**Planning Department
Transportation Development Services**

October 29, 2014

Re: Office/Warehouse, 8620 President Place
Traffic Circulation Layout
Architect's Stamp dated 10-27-14 (C17-D122)

date
10-27-14
sheet
C100

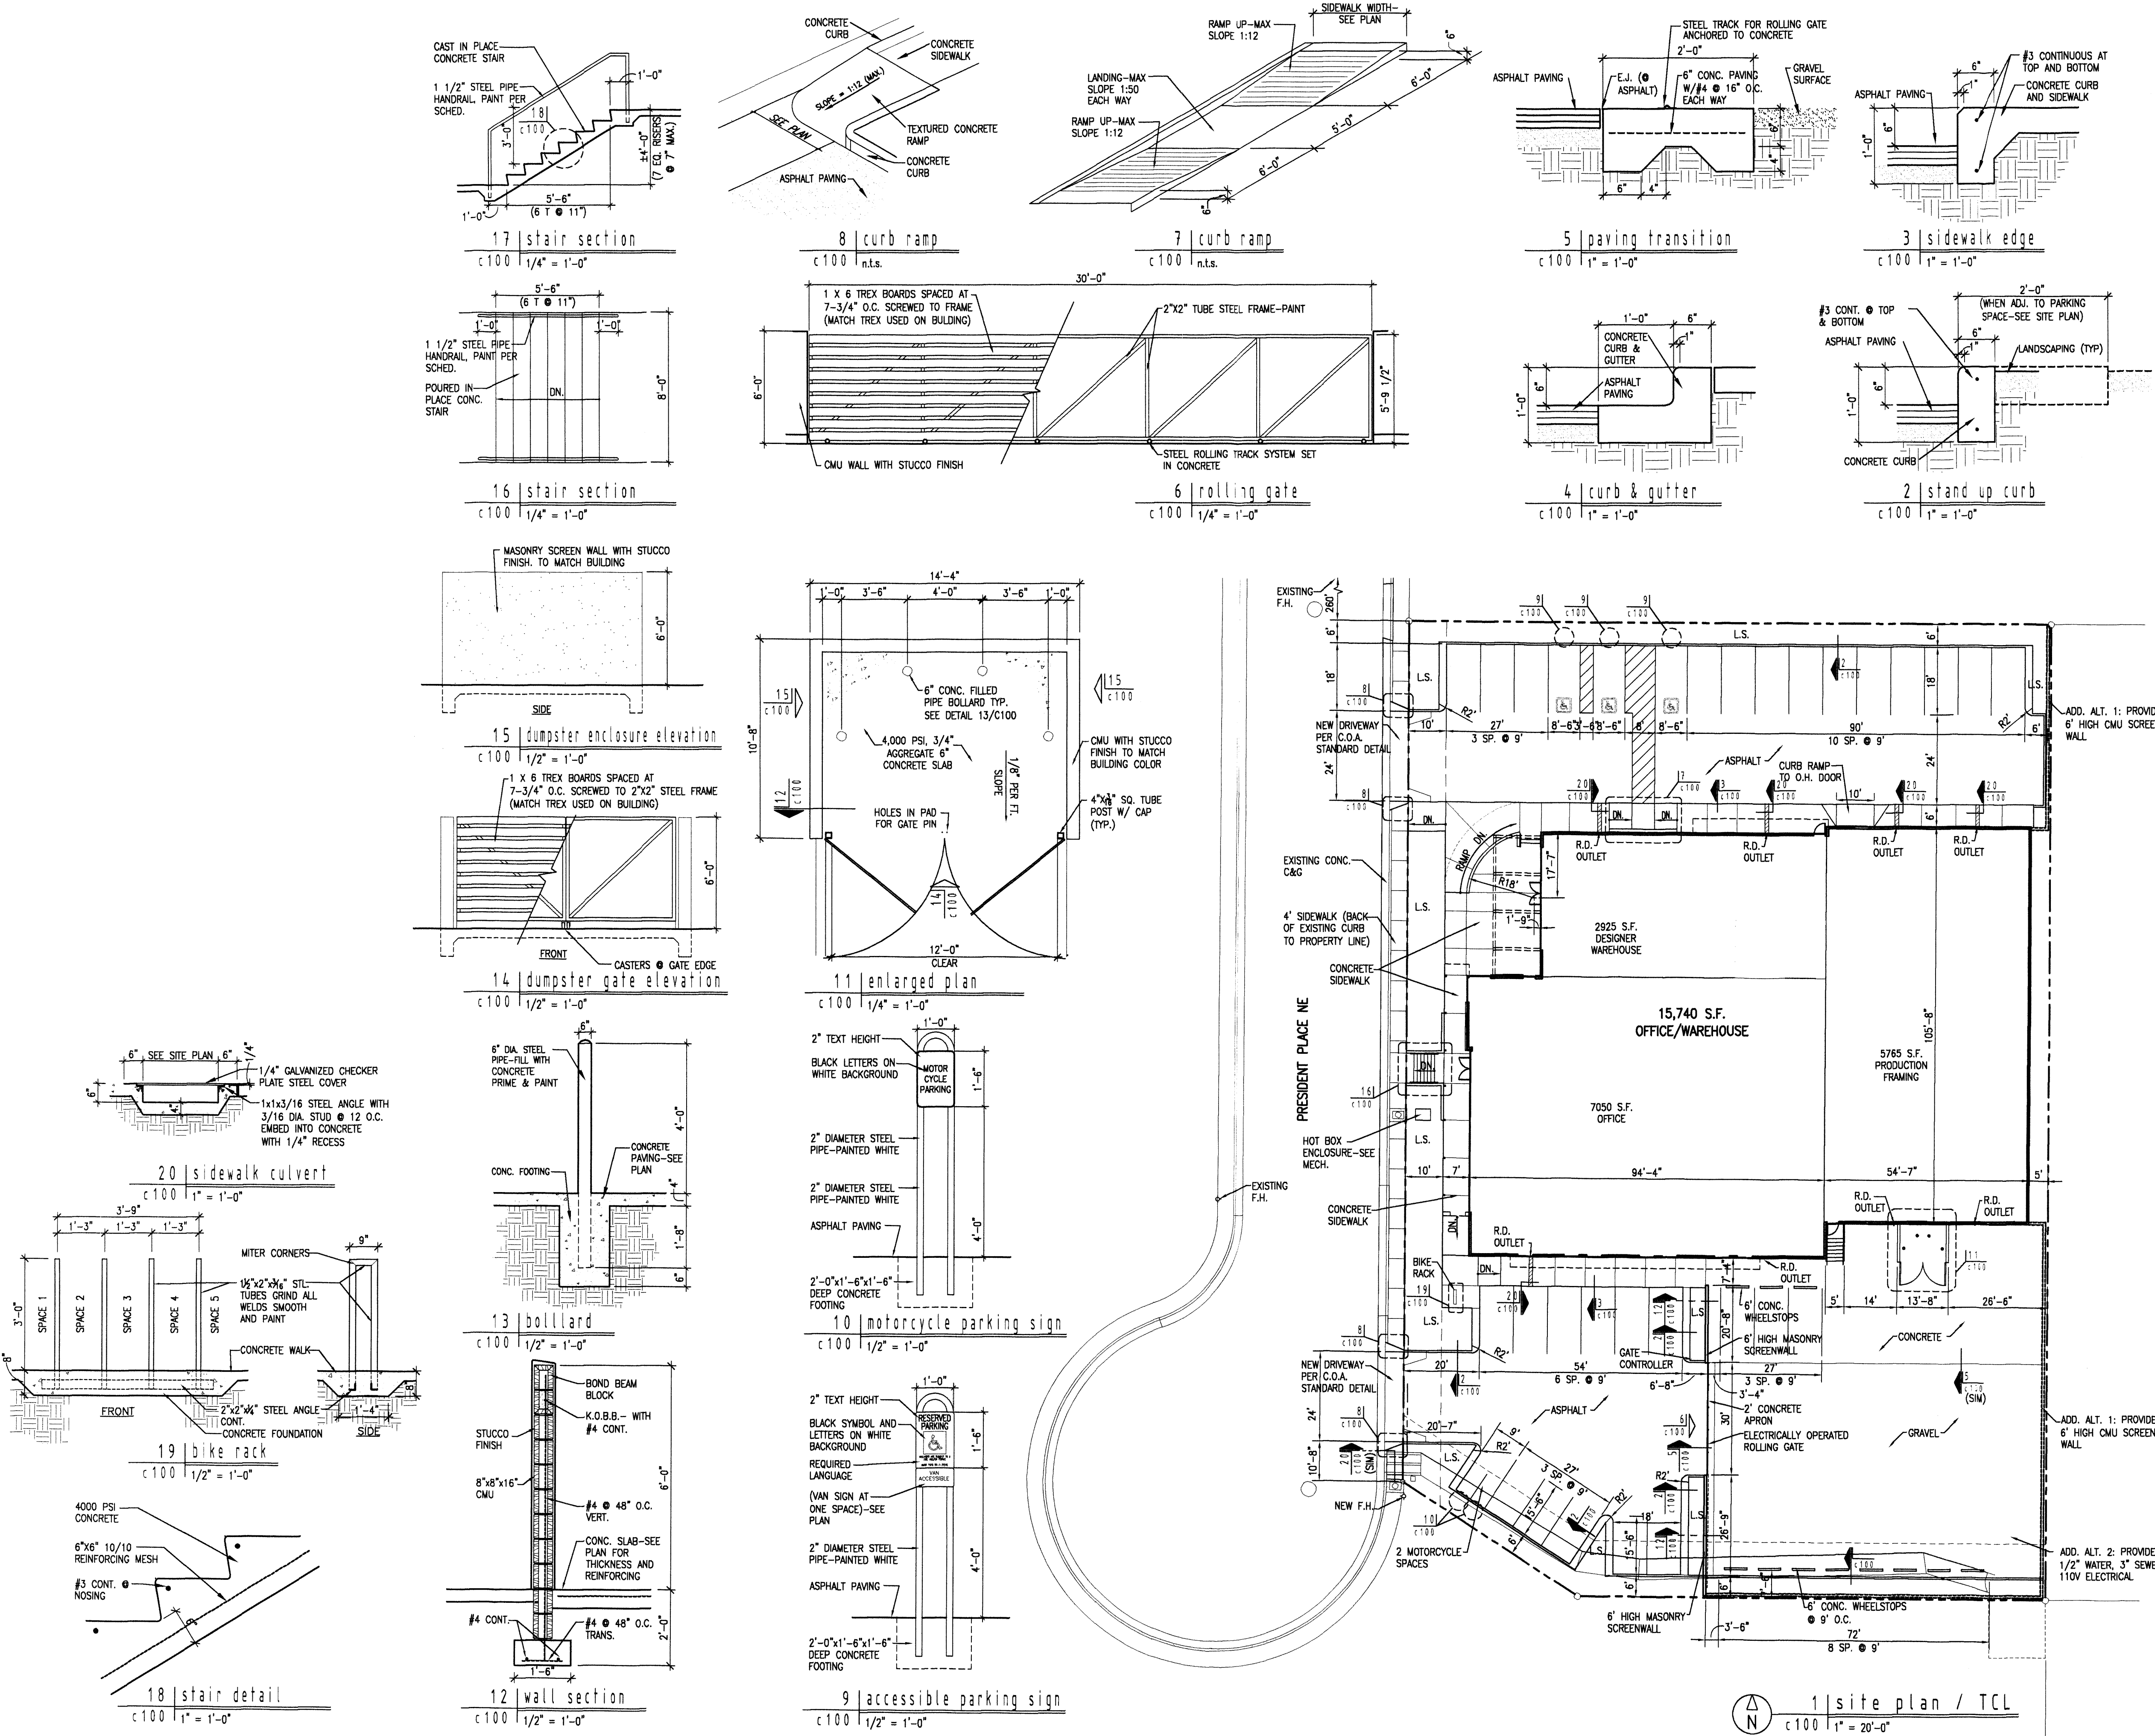
1. Please show a vicinity map showing the location of the development in relation to existing streets.
2. Identify existing pavement and right-of-way dimensions for President Place. Show existing features such as existing curb and sidewalk as a different line-type to distinguish them from proposed improvements.

3. Label the compact parking spaces by placing the words "**COMPACT**" on the pavement of each space for the parking spaces shown on the southwest corner of the site.

4. Enlarge the detail for the van accessible signs so that the text on it is legible.
5. The ADA access aisle shall have the words "**NO PARKING**" in capital letters, each of which shall be at least one foot high and at least two inches wide, placed at the rear of the parking space so as to be close to where an adjacent vehicle's rear tire would be placed. (66-1-4.1.B NMSA 1978)

6. Per the DPM, a 6 ft. wide ADA accessible pedestrian pathway is required from both President Place and the parking lot to the building entrances. Please clearly show this pathway from President Place, and provide details. Ensure that ADA accessible slopes are met. Label the sidewalk dimensions for the sidewalk along the northwest corner of the building, ensuring that the sidewalk is over 6 feet in width.

7. The design delivery vehicle route for the warehouse needs to be shown.

8. For the parking spaces within the gravel area, make sure they are called out on the plan as "8 spaces @ 9' wide X 18' long".
9. Label the existing feature immediately to the south of the property within the sidewalk area. There must be a continuous 4-foot wide ADA access on the sidewalk adjacent to the property.

10. Where is detail 4 for curb and gutter being used on-site? Clearly show limits for beginning and end of curb or gutter on-site. Clearly show beginning and end of new sidewalk on President Place.

11. Show the mini clear site triangle as per the DPM for both driveway entrances. Add the following note to the clear sight triangle: "Landscaping and signage will not interfere with clear sight requirements. Therefore, signs, walls, trees, and shrubbery between 3 and 8 feet tall (as measured from the gutter pan) will not be acceptable in this area."

12. Please specify the City Standard Drawing Number when applicable. Call out applicable COA Standard Details when calling out the new driveways and new sidewalk. Ensure ADA accessibility across driveways.

13. Be sure to get approval from Solid Waste on this site plan since they would need access to the trash bin behind the electrically operated rolling gate. Discuss with them prior to the next site plan submittal.
